**REQUEST**

Proposed Zoning: I-2(CD) (general industrial, conditional)

Approximately 63.22 acres located on the north and south side of Morris Estate Drive, east of North Graham Street, and west of IBM Drive.

JOB # 23007 DATE: 01/30/23 SCALE: 1"=150' DRAWN BY: JAC APPROVED BY: LWL RZ-1

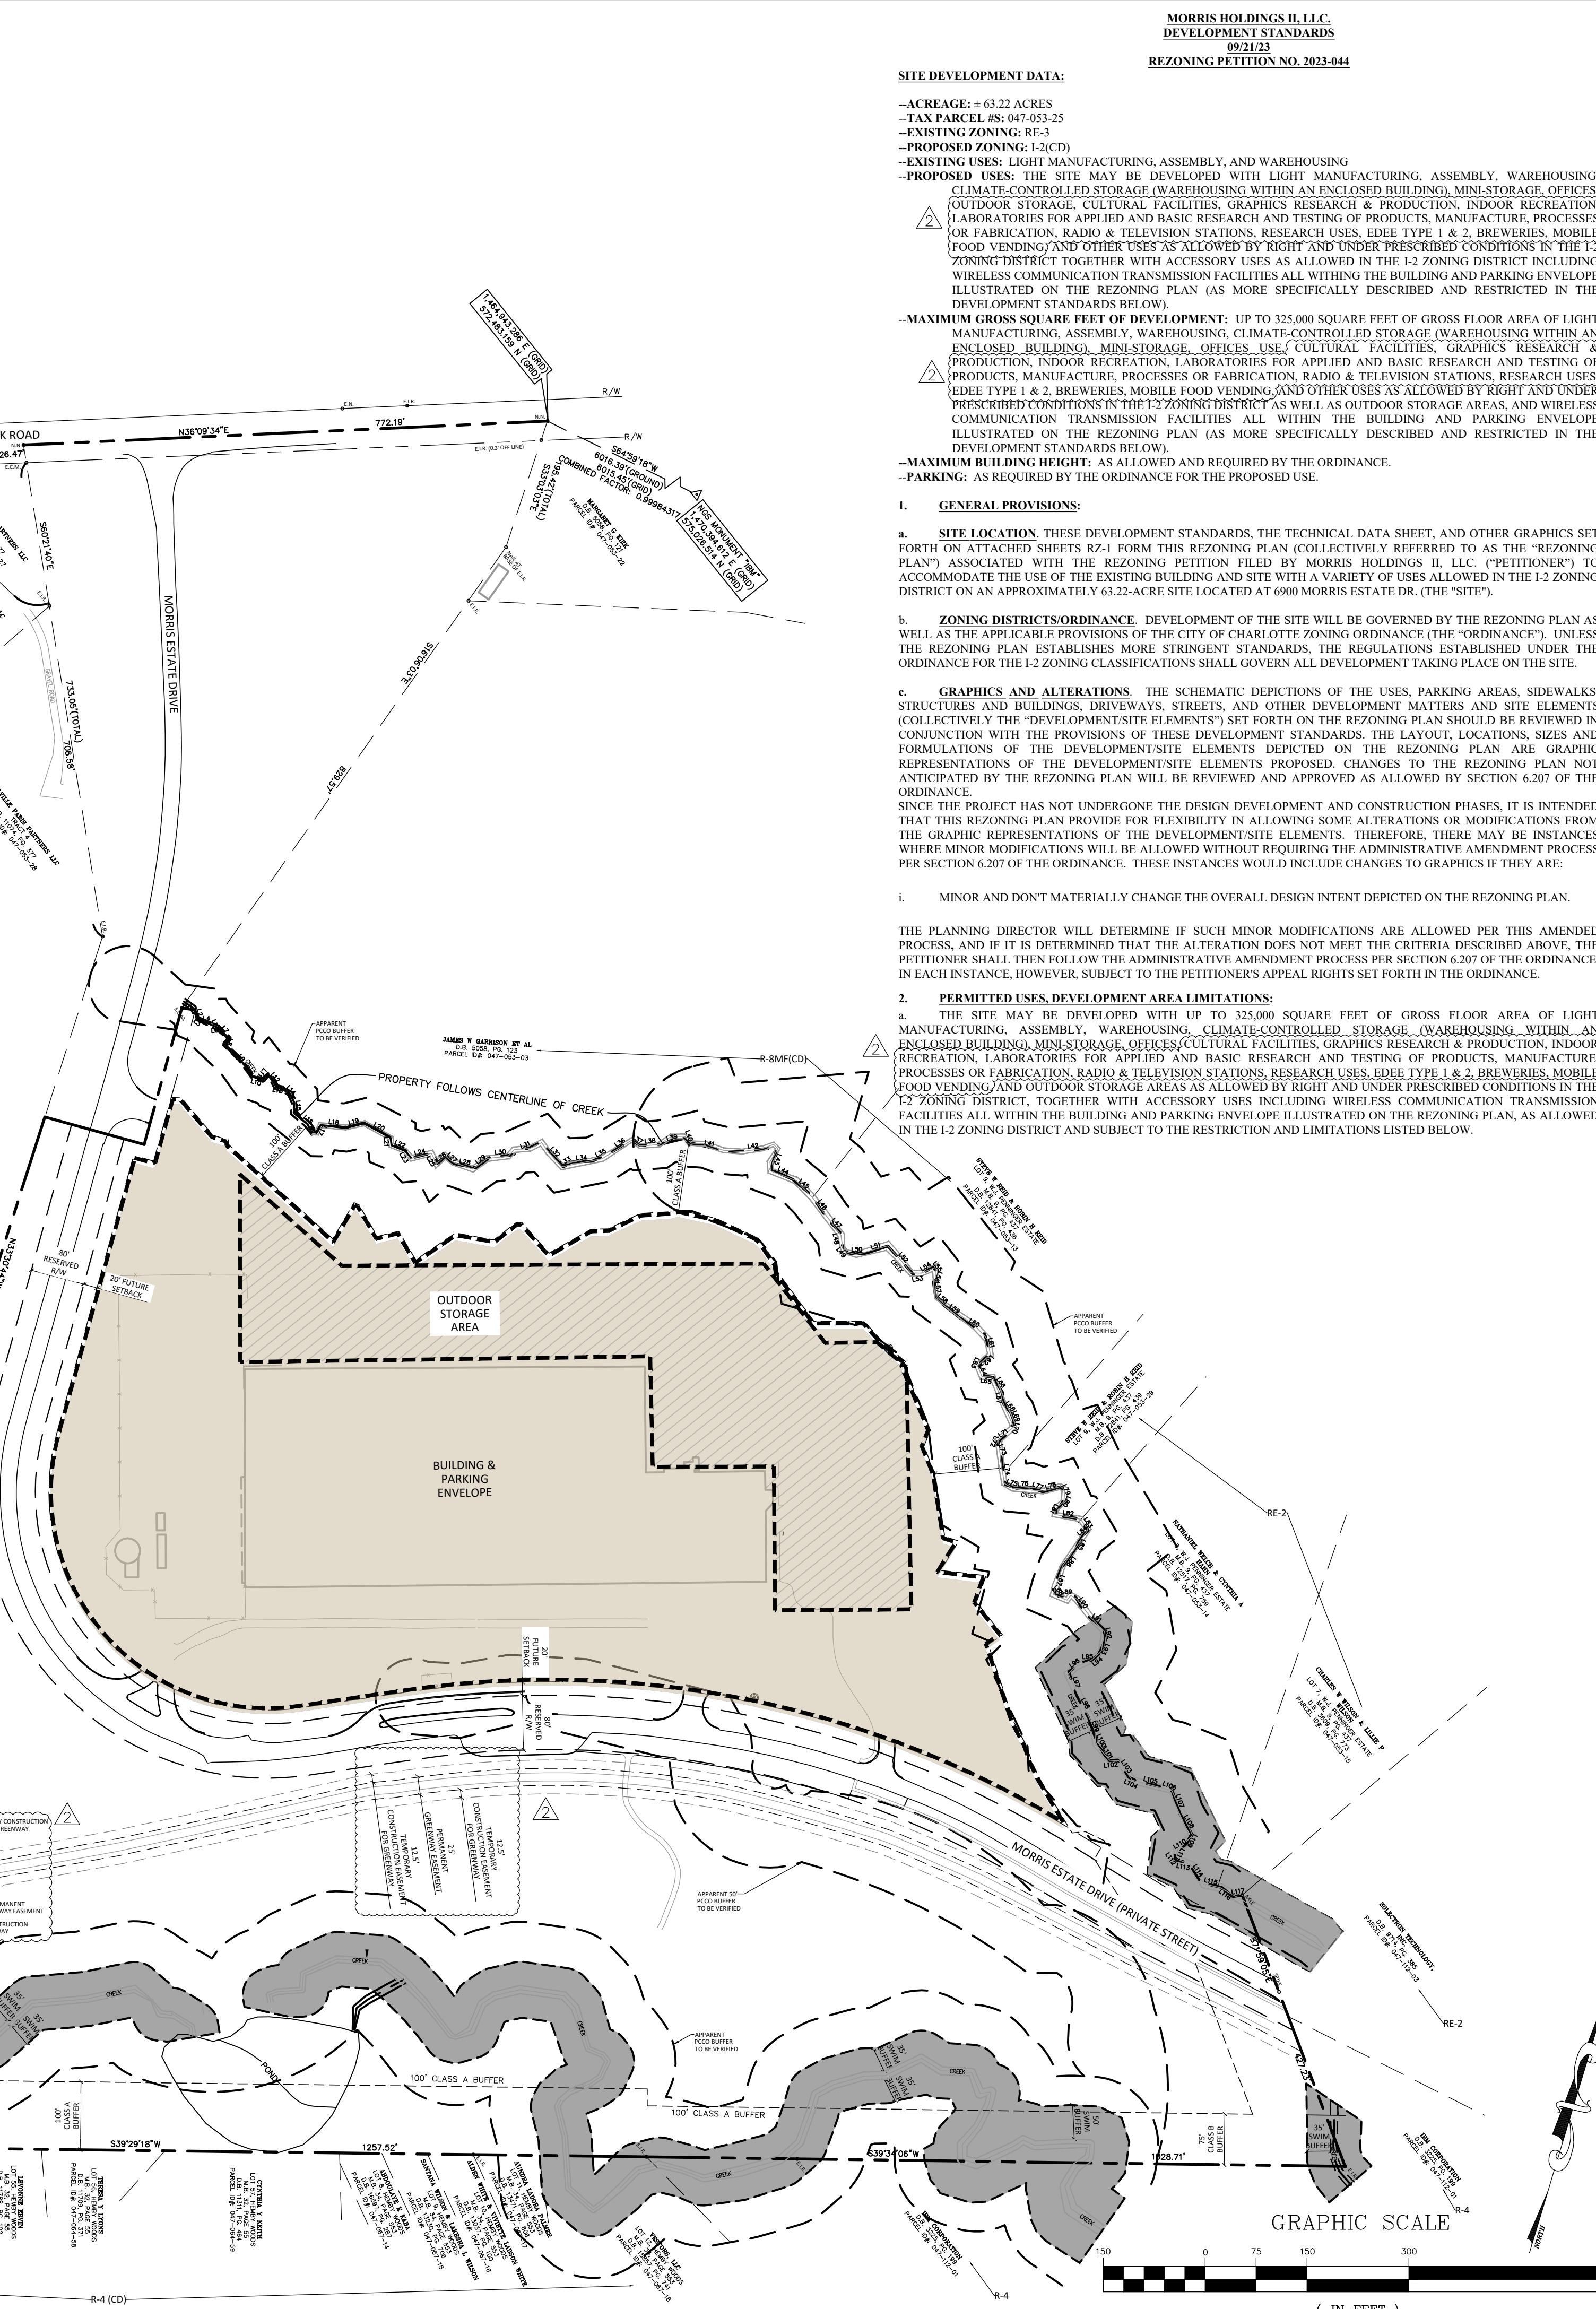
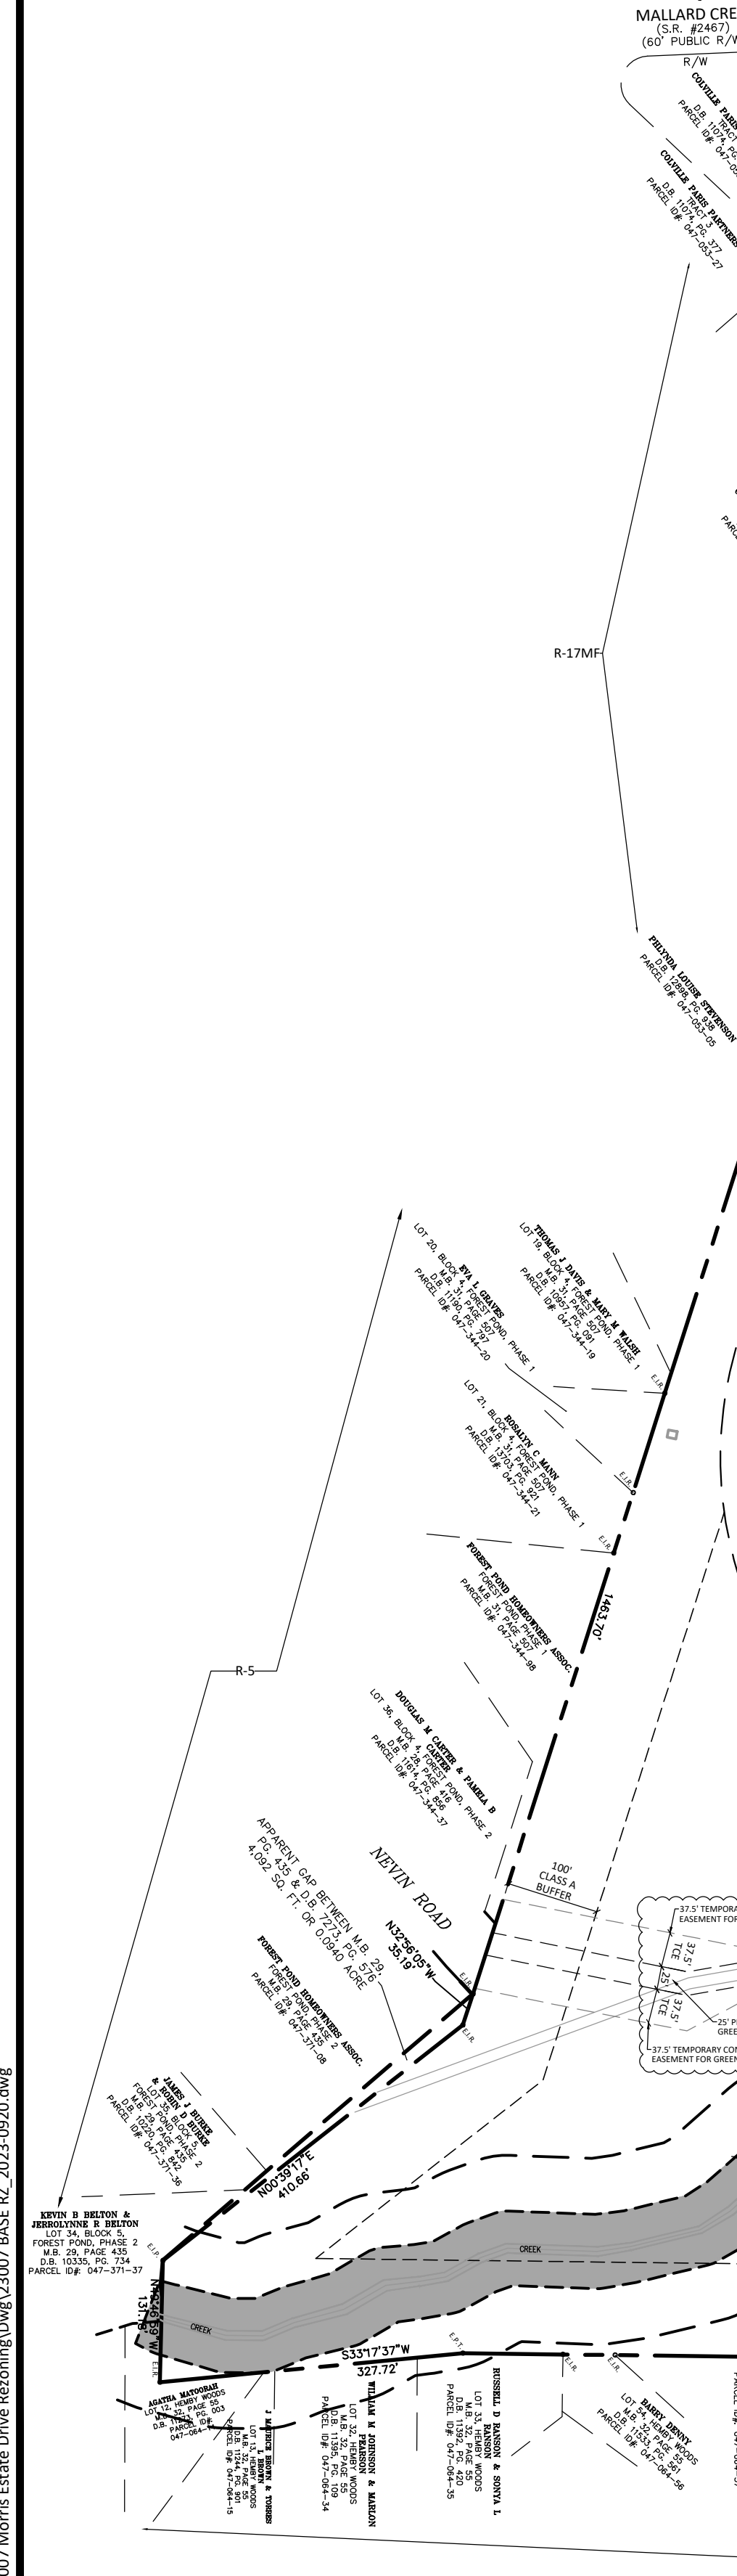
- ~~1. The previous submitted site plan identified the 100' greenway easement area adjacent to Morris Estate Drive. MCPR requests that the proposed easement be consistent with this initial proposed area, with the addition of the connection to Nevin Road. Addressed~~
